D49 TRANSPORTATION CENTER
SCHOOL DISTRICT NO 49
11971 SWINGLINE ROAD
PEYTON, CO 80831

SHEET TITLE
**INITIAL
EROSION
CONTROL PLAN
A**

CE1.1

SCALE FOR CONSTRUCTION DOCUMENTS
CE1.4

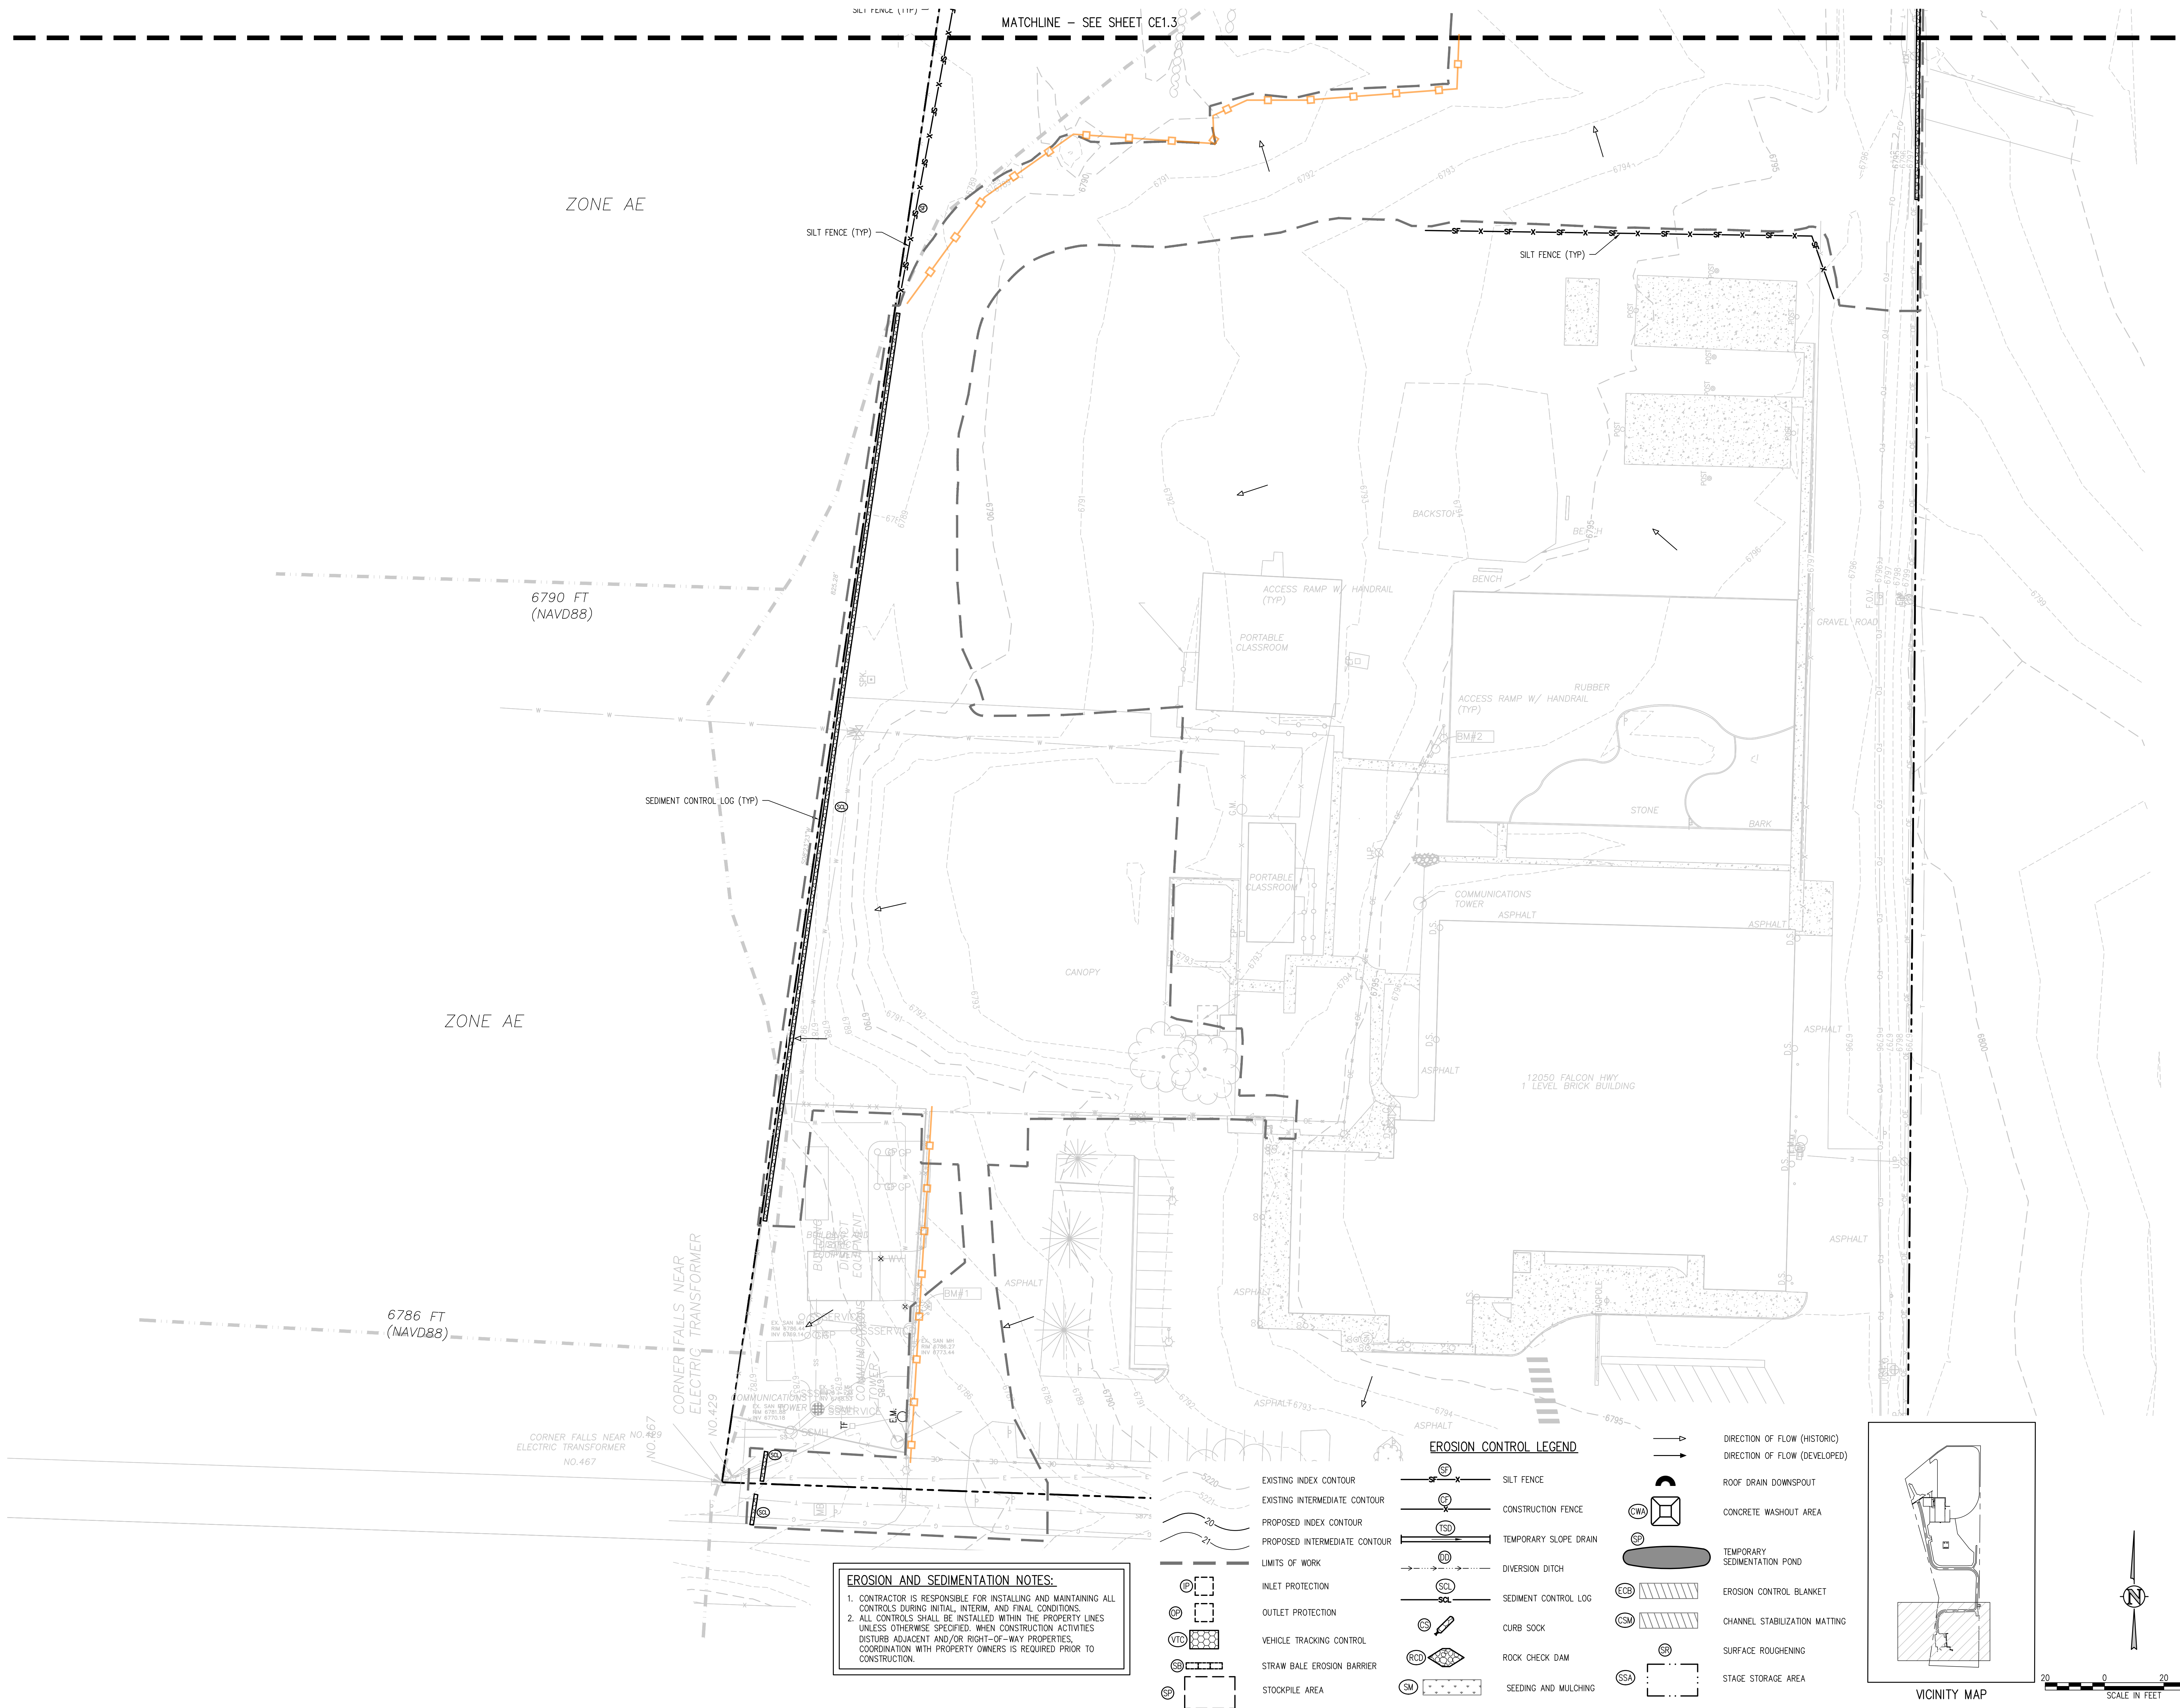
show all areas of cut/fill. Unresolved.

In accordance with the CWA detail: do not locate a CWA within 400' of any drainage pathway or waterbody. Unresolved.

is this water line proposed? if so, extend your area of disturbance

define hatching

define hatching

show typical ditch section detail unresolved.

JVA Response: To clarify the note says a "unlined CWA" could not be within 400' of a drainage pathway. The contractor is to line the CWA based on the MHFD note.

JVA Response: Area disturbance reflects the updated water and sanitary locations.

JVA Response: Hatching is asphalt, see legend notes and abbreviations sheet C0.2 (typ).

JVA Response: Hatching is Gravel, see legend notes and abbreviations sheet C0.2 (typ).

JVA Response: This is not a ditch. This is offsite flows.

CE1.7

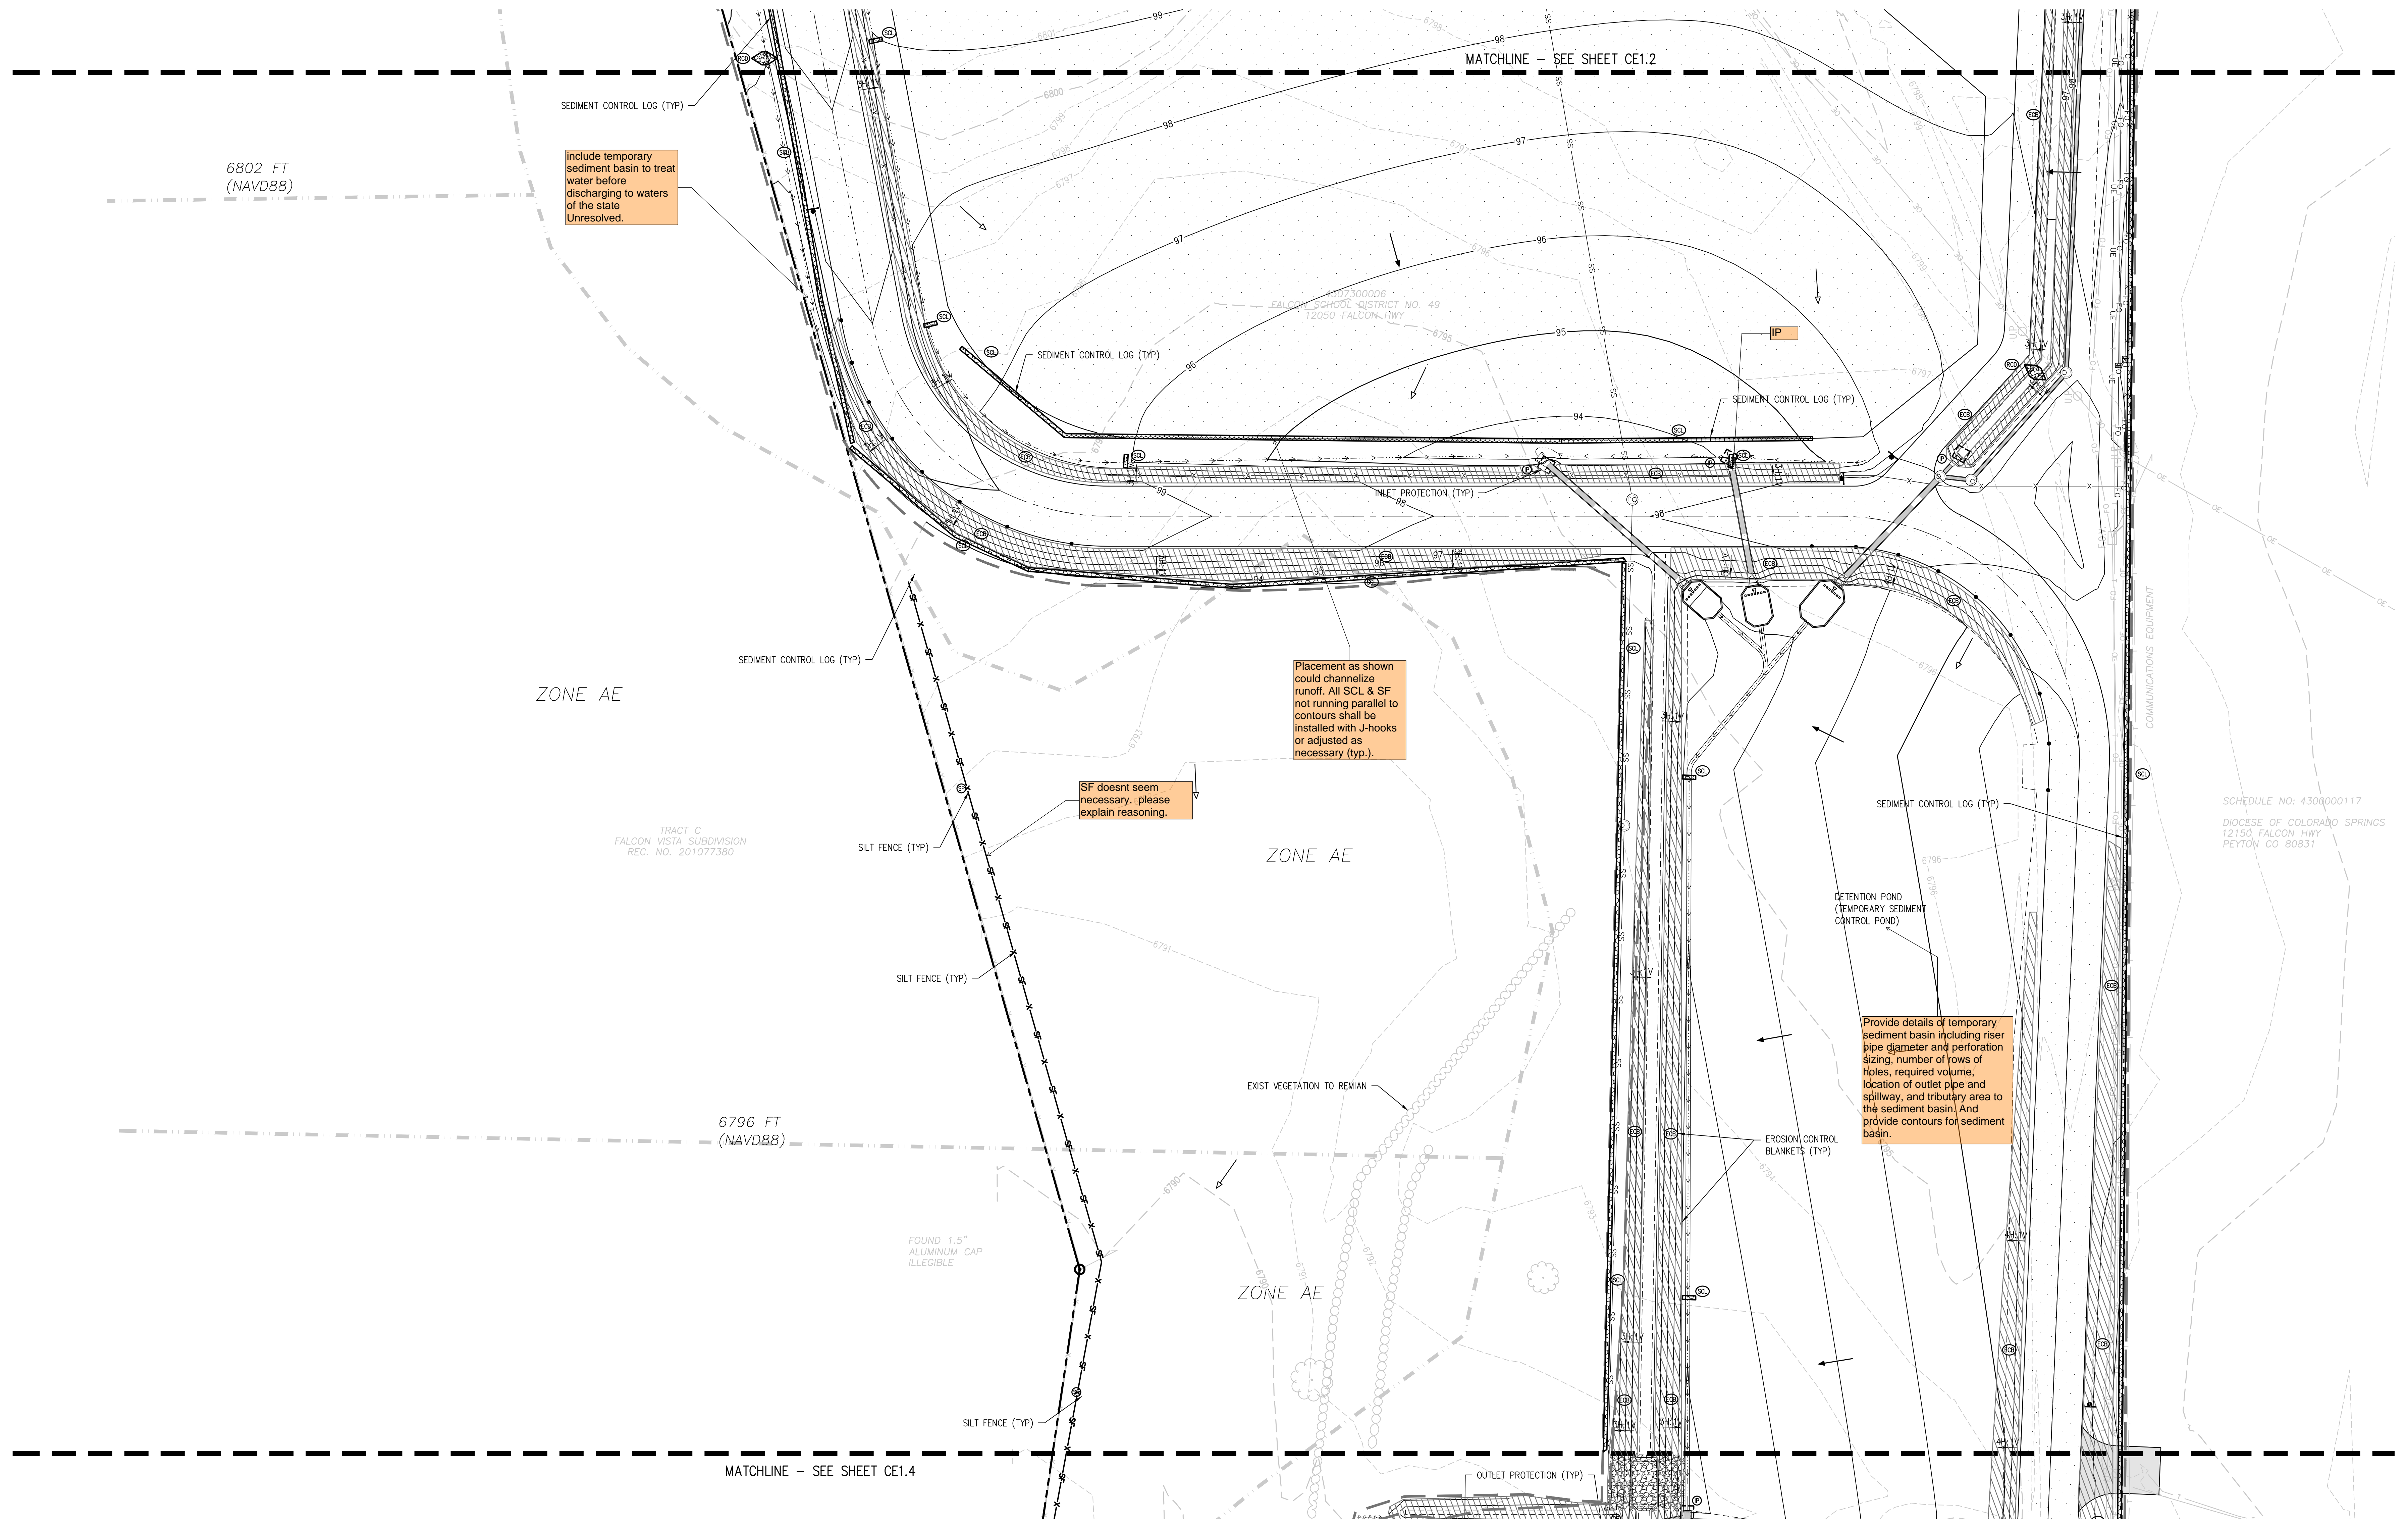
include temporary sediment basin to treat water before discharging to waters of the state. Unresolved.

SF doesnt seem necessary. please explain reasoning.

Placement as shown could channelize runoff. All SCL & SF not running parallel to contours shall be installed with J-hooks or adjusted as necessary (typ.).

Provide details of temporary sediment basin including riser pipe diameter and perforation sizing, number of tows of holes, required volume, location of outlet pipe and spillway, and tributary area to the sediment basin. And provide contours for sediment basin.

JVA Response: Check Dams are now provided for sediment treatment. Drainage path is from an upstream offsite existing basin following historic drainage patterns. Treatments shown on erosion control plans improve the historic drainage pattern that discharge to the water of the state.

JVA Response: The SF is updated to the proposed location.

JVA Response: Noted.
